SDNP/21/06404/ADJAUT

Neighbouring Authority Consultation

Proposal: Adjoining Authority Consultation - Approval of reserved matters following outline consent A/40/18/OUT for the erection of 525 No residential dwellings with associated parking, landscape, play areas & public open space.

Address: Land North of Water Lane Angmering,

Revised land use parameter plan ►

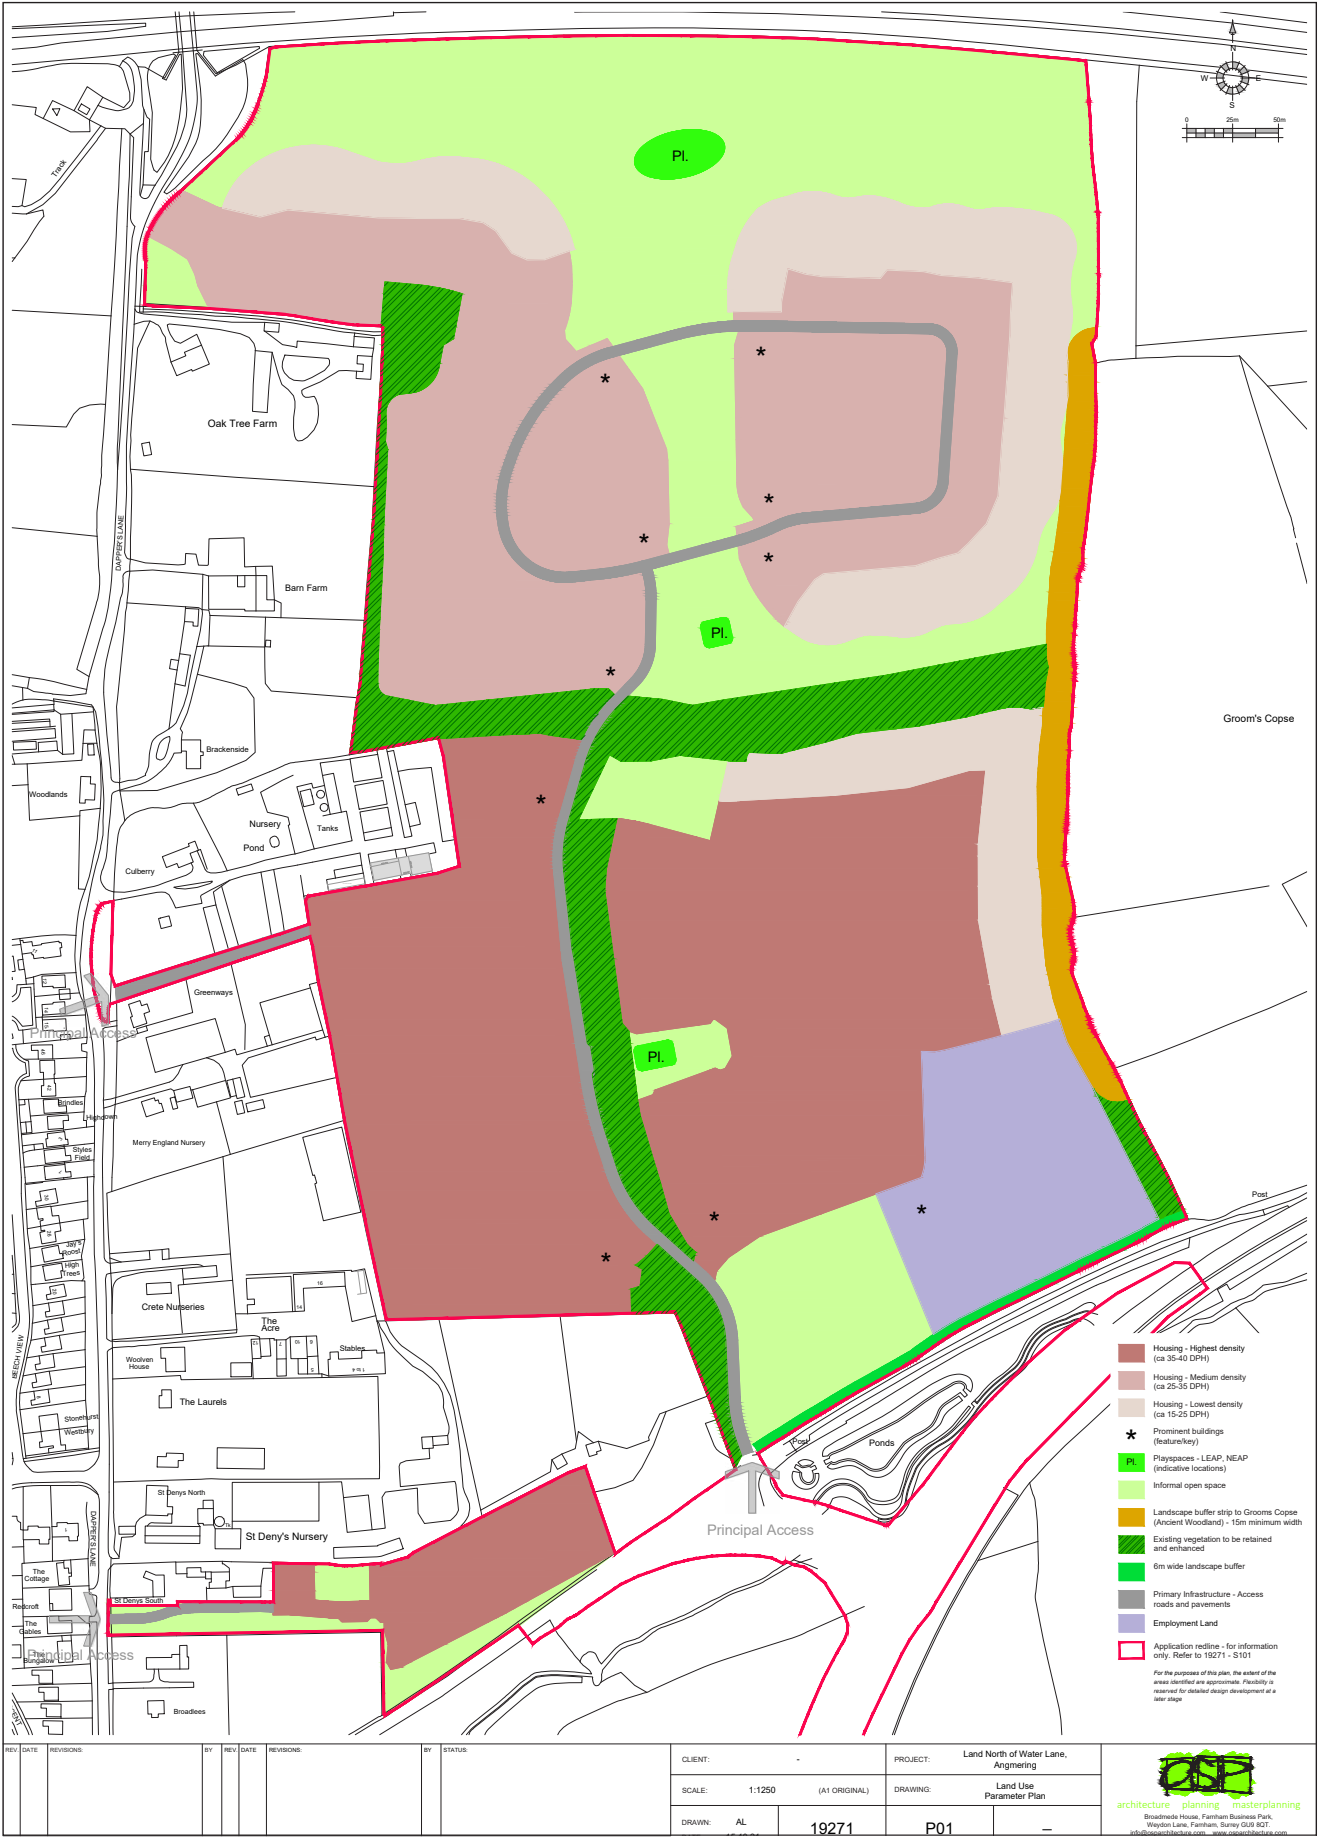
Of greatest significance to the National Park is the extension of the amended layout to the higher ground to the north, into the landscape buffer/public open space. This will affect in particular the views from the SDNP to the south-east, looking across the site and back into the National Park, where this northern field is clearly visible and contributes to the rural character. We note that the overall ridge heights AOD are not intended to change, but this does not necessarily address the noticeable urban expansion further into the northern parts of the site and away from the historic settlement core of Angmering in such views, albeit that the general principle of lower density housing to provide more of a rural edge to the site is welcomed. The SDNPA therefore considers it would be essential for the LPA to secure visualisations in order to properly understand the impacts. These would also help understand the impacts of some of the larger, more bulky (approaching 3 storey) flats to the southern end of the site, as well as the effectiveness of proposed tree planting throughout the site.
